# Statement of Common Ground with Yorkshire Wildlife Trust ~~(draft)~~

Revision ~~23~~ (tracked and unsigned)

~~October~~November 2025

- 1.1.1 This Statement of Common Ground (hereafter referred to as the 'SoCG') has been prepared to support the Examination of the Development Consent Order (DCO) application (the 'DCO Application') for Peartree Hill Solar Farm (the 'Proposed Development').

**Figure 2.11 —
Statutory/Non-statutory Sites
or Features of Nature
Conservation and Habitats
of Protected Species,
Important Habitats or Other
Diversity Features Plan**

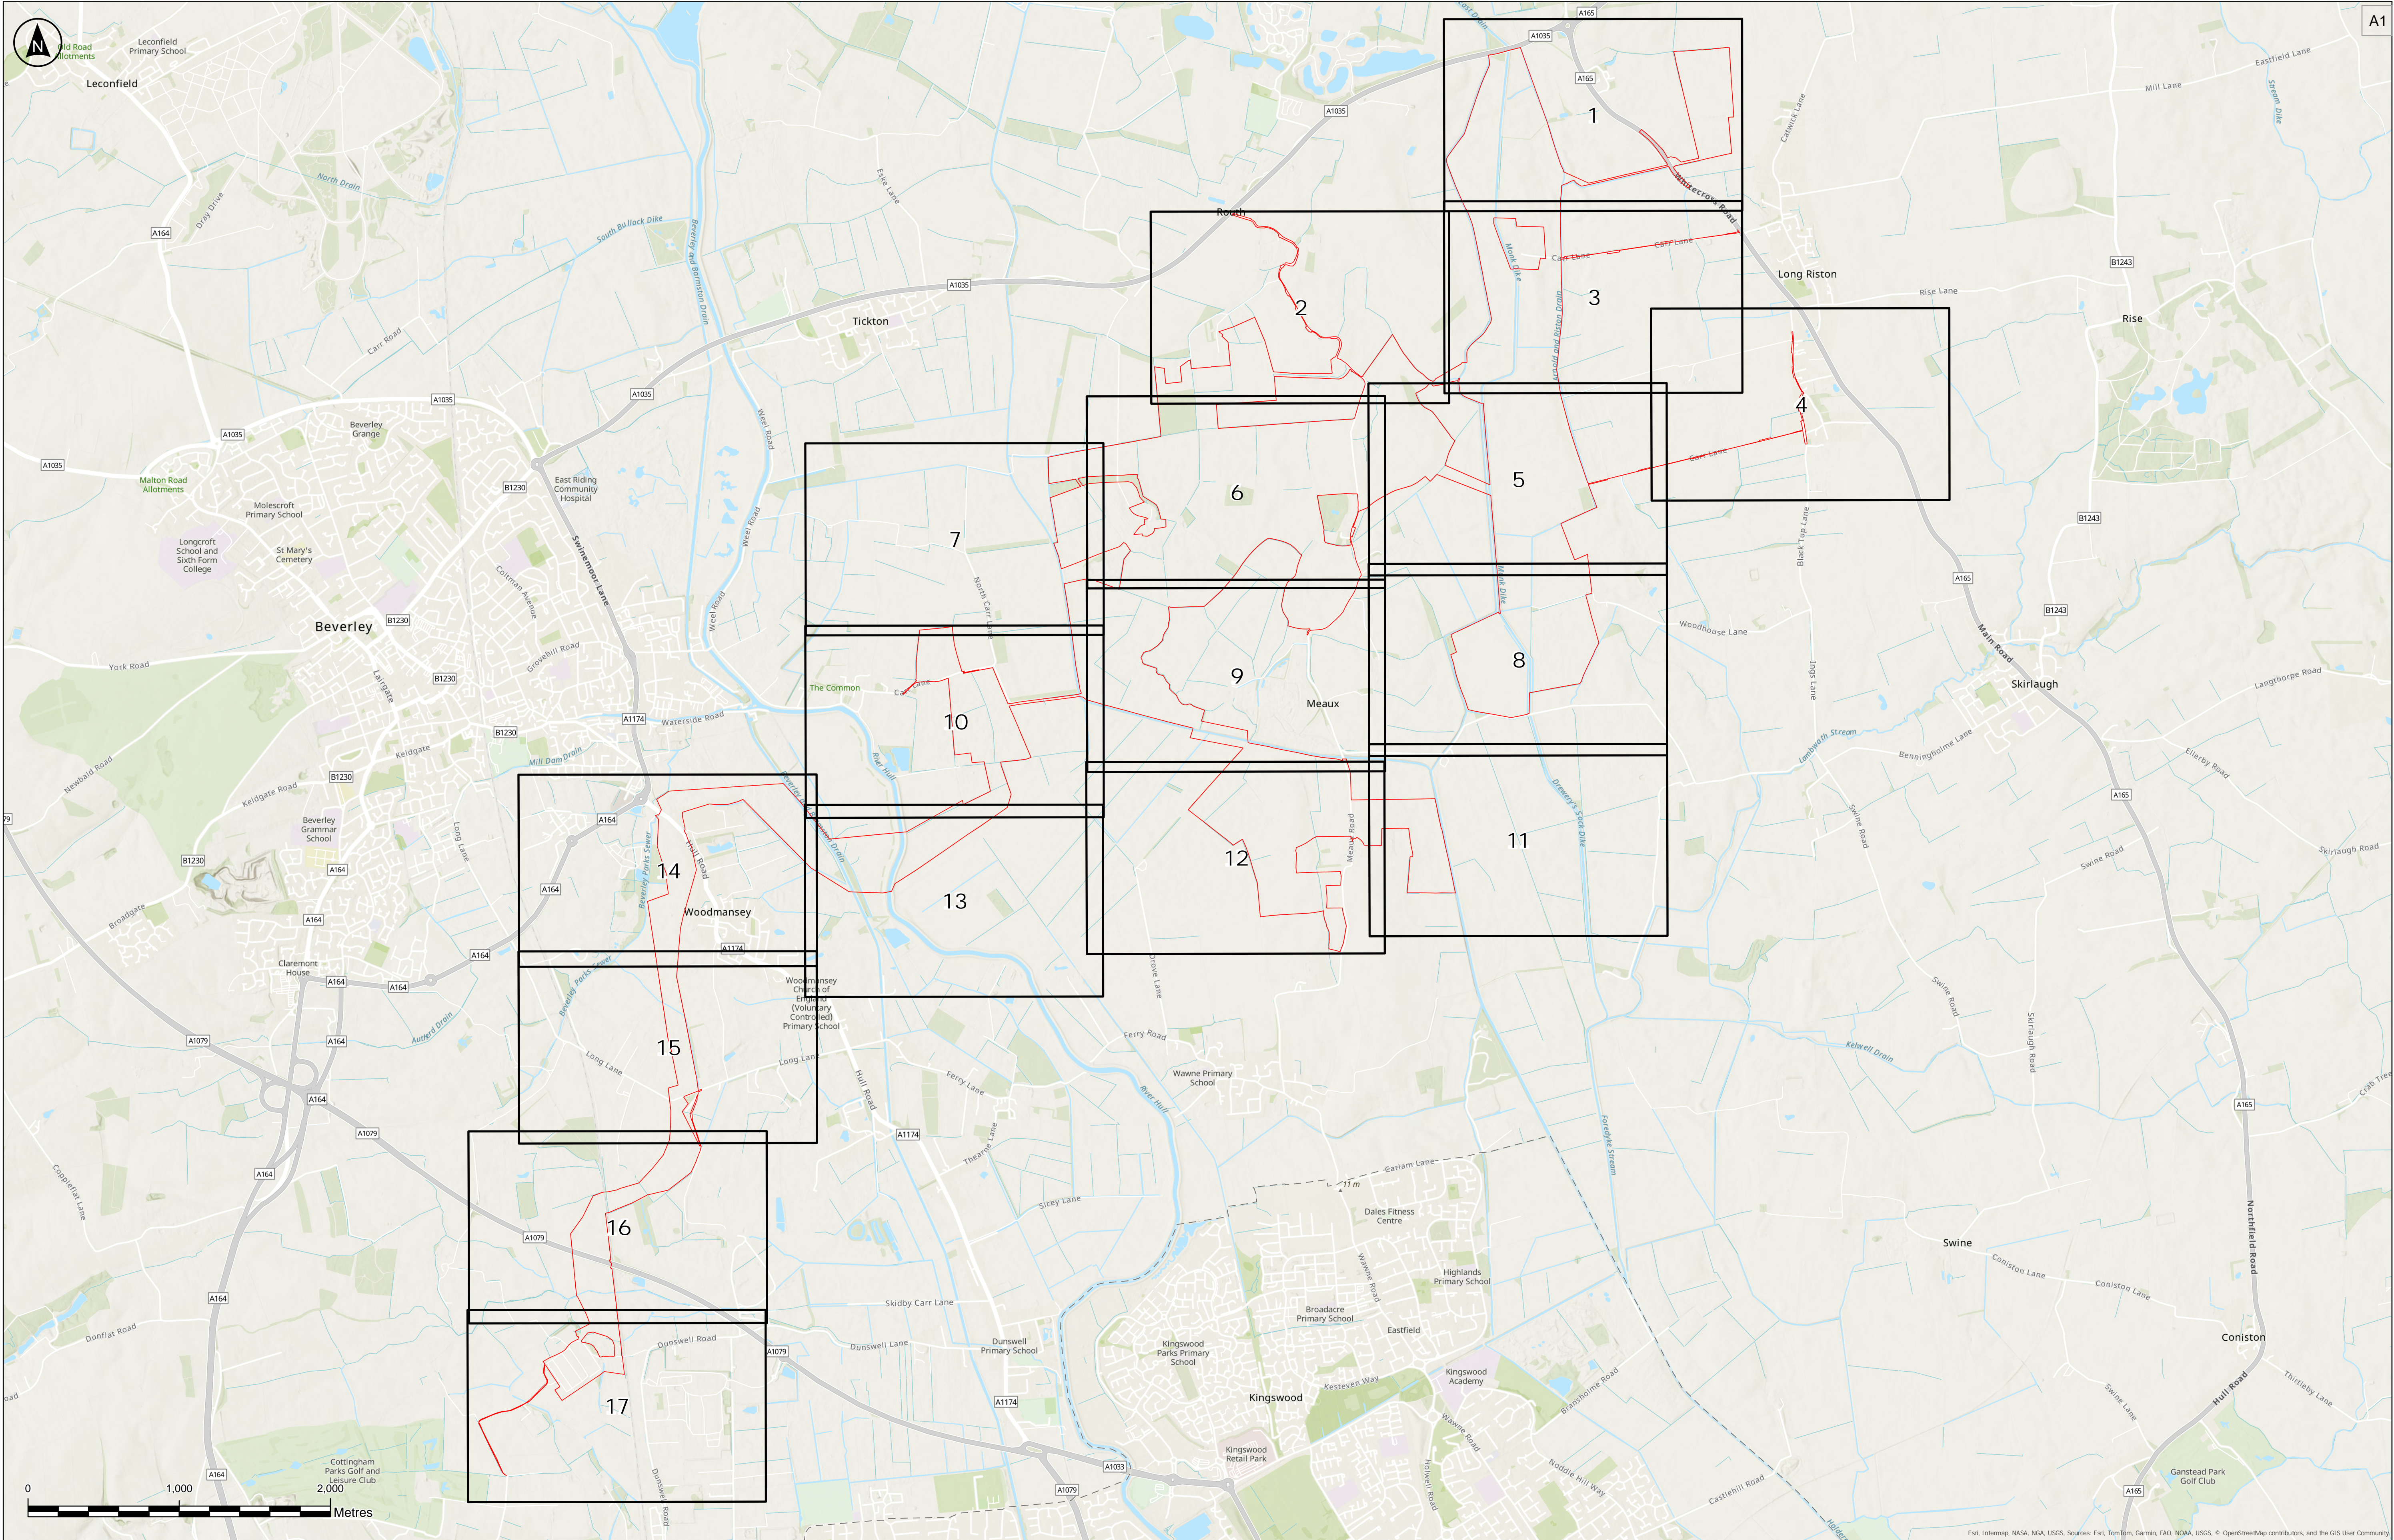
Ref	Topic	Yorkshire Wildlife Trust Position	Applicant's Position	Status
YWT01	Statutory and non-Statutory wildlife sites  <i>Biodiversity</i>	<p>In their relevant representation [RR-017], Yorkshire Wildlife Trust welcomes the removal of Land area A and Cable A-B from the Order Limits. However, Yorkshire Wildlife Trust still has concerns regarding Leven Canal Site of Special Scientific Interest (SSSI), Tophill Low SSSI, and Pulfin Bog SSSI and Yorkshire Wildlife Trust Reserve being sensitive receptors during construction. These sites form part of the Leven Carrs Wetland Scheme.</p> <p><u>Yorkshire Wildlife Trust confirmed via email on 17 October 2025 that it feels the Leven Carrs Wetland Scheme should be considered as a sensitive receptor as it is ecologically linked to the three SSSIs mentioned above.</u></p>	<p>As set out within Table 7-3 of <b>ES Volume 2, Chapter 7: Biodiversity [EN010157/APP/6.2 Revision 2]</b>, <u>since the removal of Land Area A and Cable A-B from the Order Limits prior to submission of the DCO Application (as set out in Table 4-3 of <b>ES Volume 1, Chapter 4: Alternatives and Design Iteration [APP-040]</b>), Tophill Low SSSI (approximately 5.3km from the Order Limits) and Leven Canal SSSI (approximately 1.1km from the Order Limits)</u> have been scoped out of the assessment due to distance from the Site, lack of hydrological linkages to the Proposed Development, and intervening features between the Proposed Development and the SSSIs.</p> <p>Pulfin bog SSSI is <del>over 2</del><u>approximately 3.4</u>km from the Proposed Development <u>(i.e. outside of the 2km study area for national statutory designated sites as set out in <b>ES Volume 2, Chapter 7: Biodiversity [EN010157/APP/6.2 Revision 2]</b> and is separated from the Site by the busy A1035</u></p>	Not agreed Under discussion

Ref	Topic	Yorkshire Wildlife Trust Position	Applicant's Position	Status
			<p>road and extensive areas of farmland, therefore has not been included within the assessment.</p> <p>Leven Carrs Wetland Scheme is not a statutory or non-statutory designated site and therefore has not been assessed as an ecological receptor.</p> <p>Furthermore, Pulfin Bog SSSI, Leven Canal SSSI and Tophill Low SSSI are all situated upstream of the River Hull. Measures aimed to reduce potential effects to the River Hull will be included within the Construction Environmental Management Plan, if required. However, given that works within 50m of the River Hull are restricted to horizontal directional drilling associated with the grid connection cable route under the river (a commitment for HDD launch/receptor pits to be positioned a minimum of 50m from Main Rivers is secured in the <b>Outline Construction Environmental Management Plan [EN010157/APP/7.2 Revision 72]</b>), it is anticipated that the measures within the <b>Outline Construction Environmental Management Plan [EN010157/APP/7.2</b></p>
